**WELWYN HATFIELD BOROUGH COUNCIL  
EXECUTIVE DIRECTOR - PLANNING, PUBLIC PROTECTION AND GOVERNANCE**

**DELEGATED APPLICATION**

**Application No:** 6/2021/2600/HOUSE  
**Location:** 28 Thistle Drive Hatfield AL10 9FQ  
**Proposal:** Conversion of roof space to habitable use to include a front and rear dormer, 1 x skylight, and the erection of a single storey front, side and rear extension  
**Officer:** Ms Ashley Ransome

**Recommendation:** Refused

PROPOSED FIRST FLOOR PLAN
(scale 1:50)

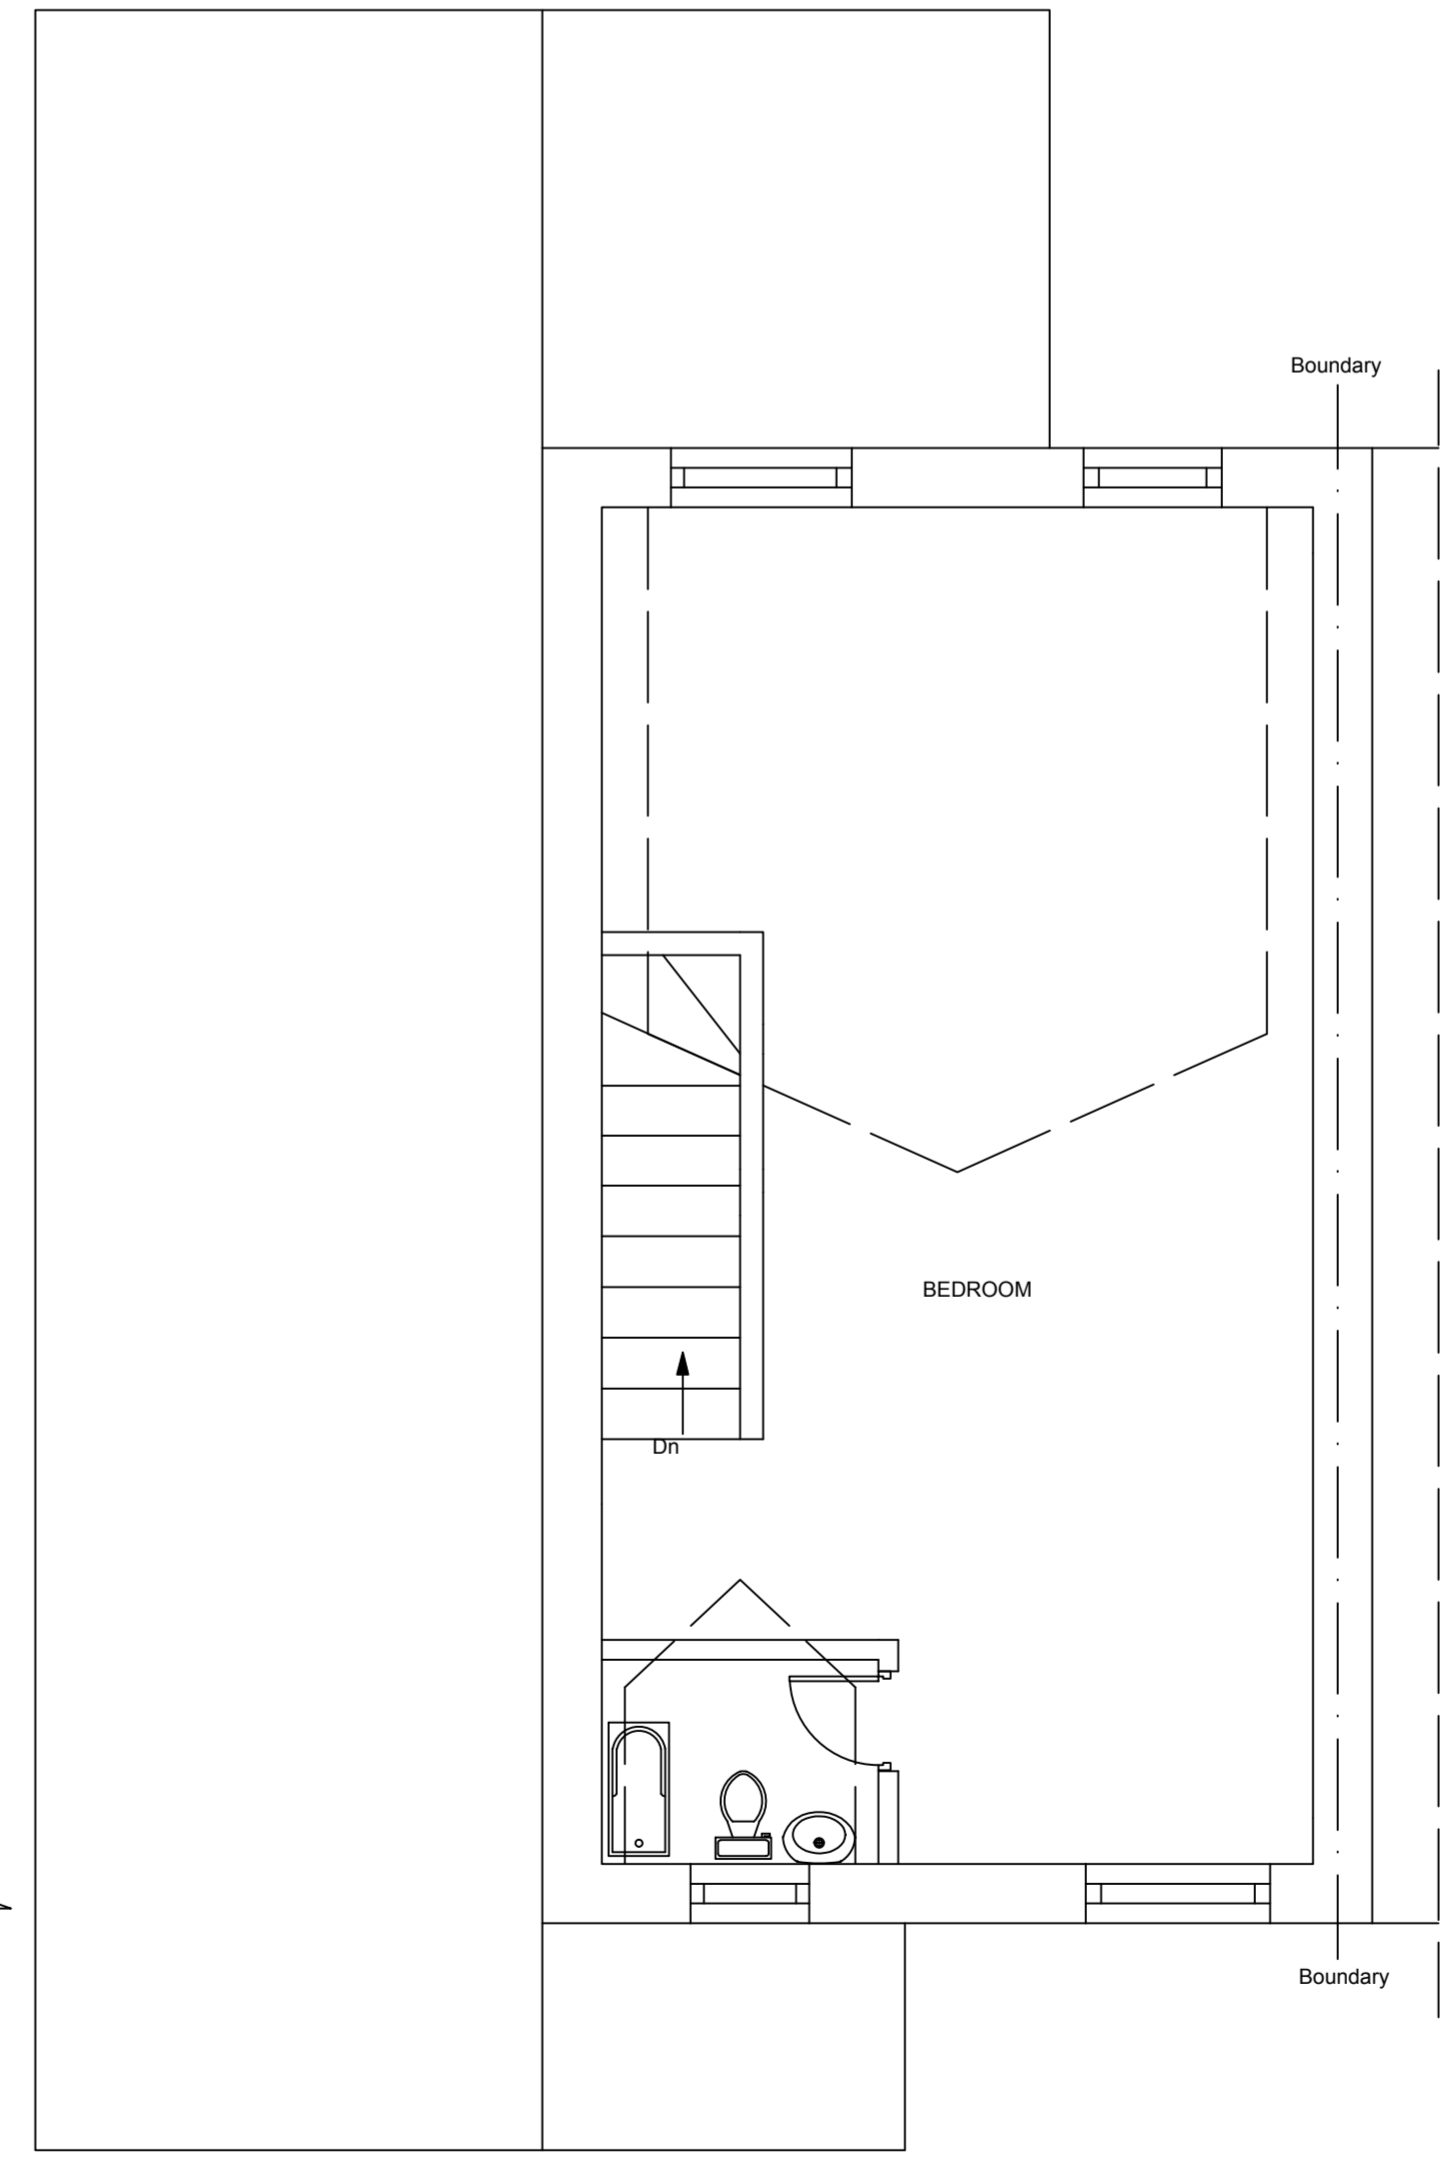
<p>The Council's Supplementary Design Guidance states at paragraph 5.2 that extensions should be designed to complement and reflect the design and character of the host dwelling and they should be subordinate in scale. Extensions must not reduce the amount of space around the dwelling to such an extent that the dwelling looks cramped on its site, and the spacing of buildings adjacent to and in the locality of the site should be reflected.</p> <p>It is considered that the proposed single storey front-side-rear wrap around extension would fail to represent a subservient addition to that of the existing dwelling. This is because it would create a significantly larger footprint than that of the existing dwelling, appearing over dominant and excessive.</p> <p>As a consequence of the above, it is considered that the proposed development would not reflect the character and appearance of the surrounding area and it would have a harmful impact upon the character of the dwelling. Accordingly, it is considered that the proposed development represents a poor standard of design and is therefore contrary to Policies D1 and D2 of the Welwyn Hatfield District Plan 2005, Policy SP9 of the Welwyn Hatfield Draft Local Plan 2016, the Welwyn Hatfield Supplementary Design Guidance 2005 and the National Planning Policy Framework 2021.</p>

<p><b>Impact on neighbours</b></p>	<p>The impact of the proposed development on the residential amenity of neighbouring dwellings is considered in terms of the impact on neighbouring properties access to day/sun/sky light, privacy, overbearing and overshadowing. Policy D1 of the District Plan seeks to provide a good standard of design in all new development. The Council's SPD on design supplements Policy D1 outlining that residential applications for extensions and alterations should not cause loss of light or be unduly dominant from adjoining properties, as a result of either the depth of the projection, the height or proximity of the extension.</p> <p>No neighbour representations have been received.</p> <p>Due to the distance, it is considered that occupants of neighbouring properties to the east and south of the application site would not be negatively impacted as a result of the proposed development. There are no immediate neighbouring dwellings to the front of the site.</p> <p>With respect to the neighbouring dwelling adjoining the application site at No.26, whilst a single storey rear extension would be visible, it is not considered to pose significant impacts to the amenity of the neighbouring occupants at No.26. This is because it is of single storey level and sited off of the boundary.</p> <p>With the above, it is therefore considered that the size, scale, siting and design of the proposed development would have minimal impact on the residential amenity of the surrounding neighbouring properties and is considered acceptable and is in accordance with Policy D1 of the Welwyn Hatfield District Plan, Policy SADM11 of the Welwyn Hatfield Draft Local Plan 2016, the Welwyn Hatfield Supplementary Design Guidance 2005 and the National Planning Policy Framework 2021.</p>

PROPOSED FRONT ELEVATION
(scale 1:50)

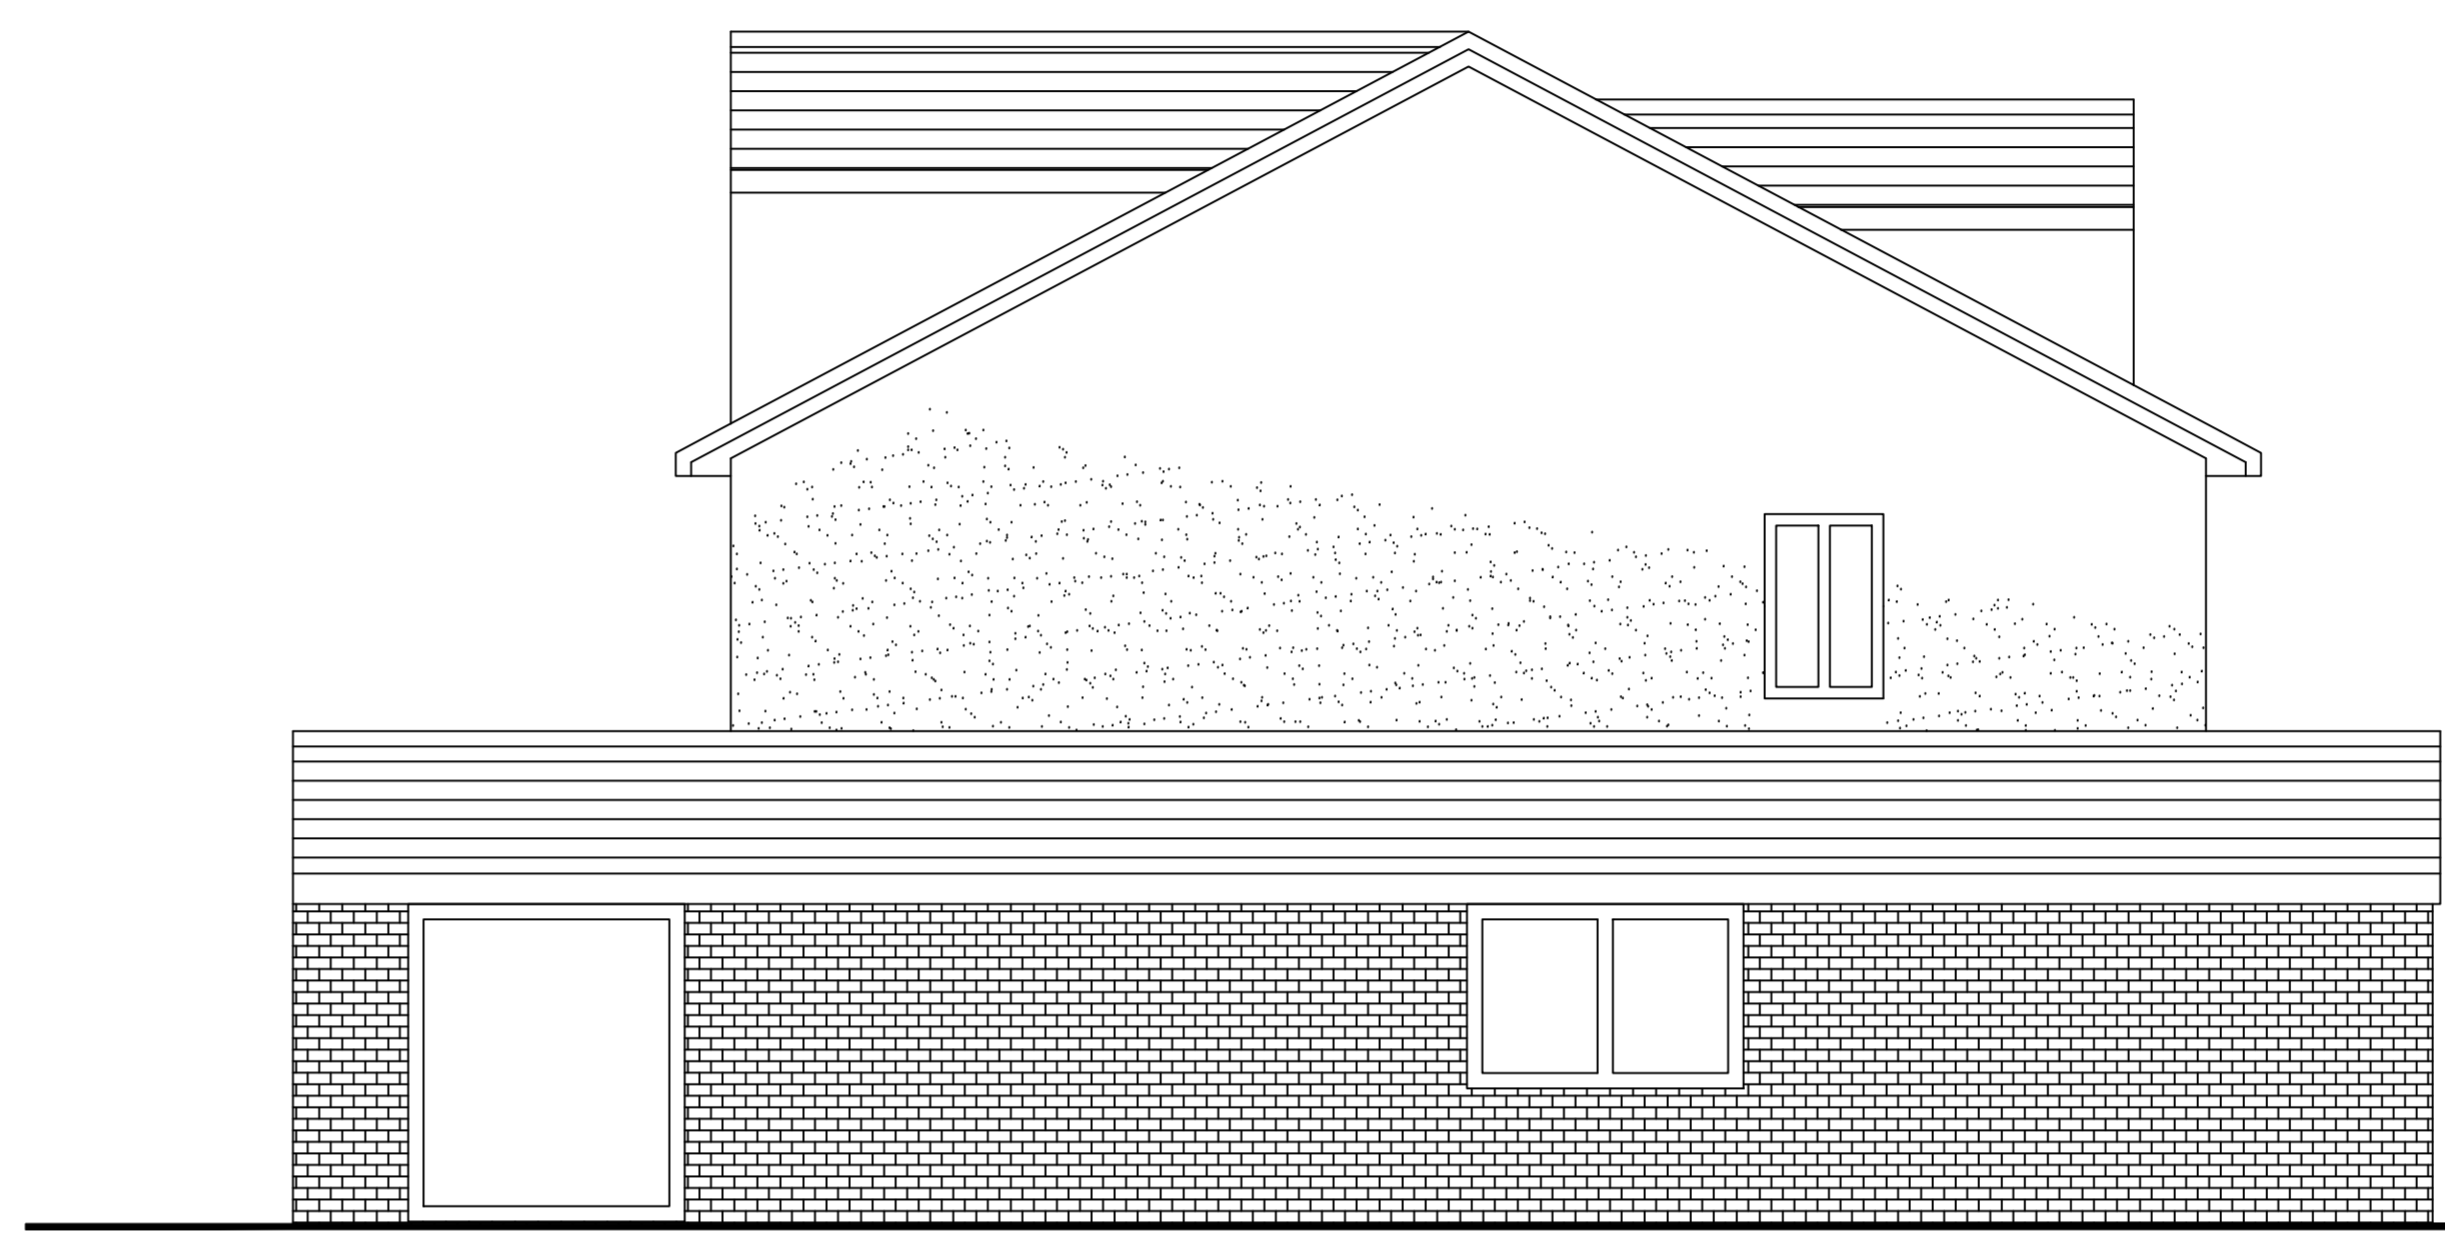
<b>responses</b>	
<b>Consultees and responses</b>	Hatfield Town Council – Major Objection- The ground floor extension is very large and over powers the existing building. The rear dormer is overwhelming. The front dormer is not so huge but really looks like a 3 storey town house rather than a 2 storey with loft conversion. Not in keeping, overdevelopment and creates an aesthetically confusing development.
<b>Relevant Policies</b>	
<input checked="" type="checkbox"/> NPPF <input checked="" type="checkbox"/> D1 <input checked="" type="checkbox"/> D2 <input type="checkbox"/> GBSP1 <input checked="" type="checkbox"/> GBSP2 <input checked="" type="checkbox"/> M14 <input checked="" type="checkbox"/> Supplementary Design Guidance <input checked="" type="checkbox"/> Supplementary Parking Guidance <input checked="" type="checkbox"/> Interim Policy for car parking and garage sizes  <u>Draft Local Plan Proposed Submission August 2016:</u> SP1- Delivering Sustainable Development SP9- Place Making and High Quality Design SADM11- Amenity and Layout SADM12- Parking, Servicing and Refuse

<b>Main Issues</b>	
<b>Design (form, size, scale, siting) and Character (appearance within the streetscene)</b>	<p>The National Planning Policy Framework 2021 (NPPF 2021) has a strong emphasis on good quality design than its predecessor. Paragraph 126 clearly advises that the creation of high-quality buildings and places is fundamental to what the planning and development process should achieve, and that good design is a key aspect of sustainable development. Paragraph 130 of the NPPF further advises that decisions should ensure developments will function well, be visually attractive, sympathetic to local character and establish a strong sense of place. Paragraph 134 is clear that “development that is not well designed should be refused, especially where it fails to reflect local design policies.”</p> <p>Policy GBSP2 of the Welwyn Hatfield District Plan 2005 states that development within the specified settlements will be limited to that which is compatible with the maintenance and enhancement of their character. Policy D1 requires the standard of design in all new development to be of a high quality and Policy D2 requires all new development to respect and relate to the character and context of the area in which it is proposed. The above objectives are broadly consistent with Policies SP1 and SP9 of the Council’s Emerging Local Plan 2016. The Welwyn Hatfield District Plan Supplementary Design Guidance (SDG) supplements the policies contained in the District Plan.</p> <p>The Council’s Supplementary Design Guidance states at paragraph 5.2 vi that ‘dormer windows should be contained within the roof slope, be subservient to the roof of the property and be in proportion to the existing fenestration of the property. They must not extend above the ridge height of the existing dwelling and the dormer cheeks should be at least 1 metre from the flank wall of the property or of the party wall with the adjoining property.’</p> <p>The proposed rear dormer does not comply with the above as it is not considered to be of modest proportions and limited extent so as to not dominant the existing roof slope, thus it is therefore considered unacceptable. Moreover, the property does not benefit from Permitted Development Rights for such a proposal as these were removed through the granting of permission of development of this site under references S6/2001/0577/FP and S6/2001/1338/FP.</p>

1. The proposed development, by virtue of its size, scale, design and layout, would fail to represent a subservient addition to that of the existing dwelling, not reflecting the local distinctiveness, to the detriment of the character and appearance of the existing dwelling and surrounding area. Accordingly, the proposed development represents a poor standard of design and is therefore contrary to Policies D1 and D2 of the Welwyn Hatfield District Plan 2005, Policy SP9 of the Welwyn Hatfield Draft Local Plan 2016, the Welwyn Hatfield Supplementary Design Guidance 2005 and the National Planning Policy Framework 2021.
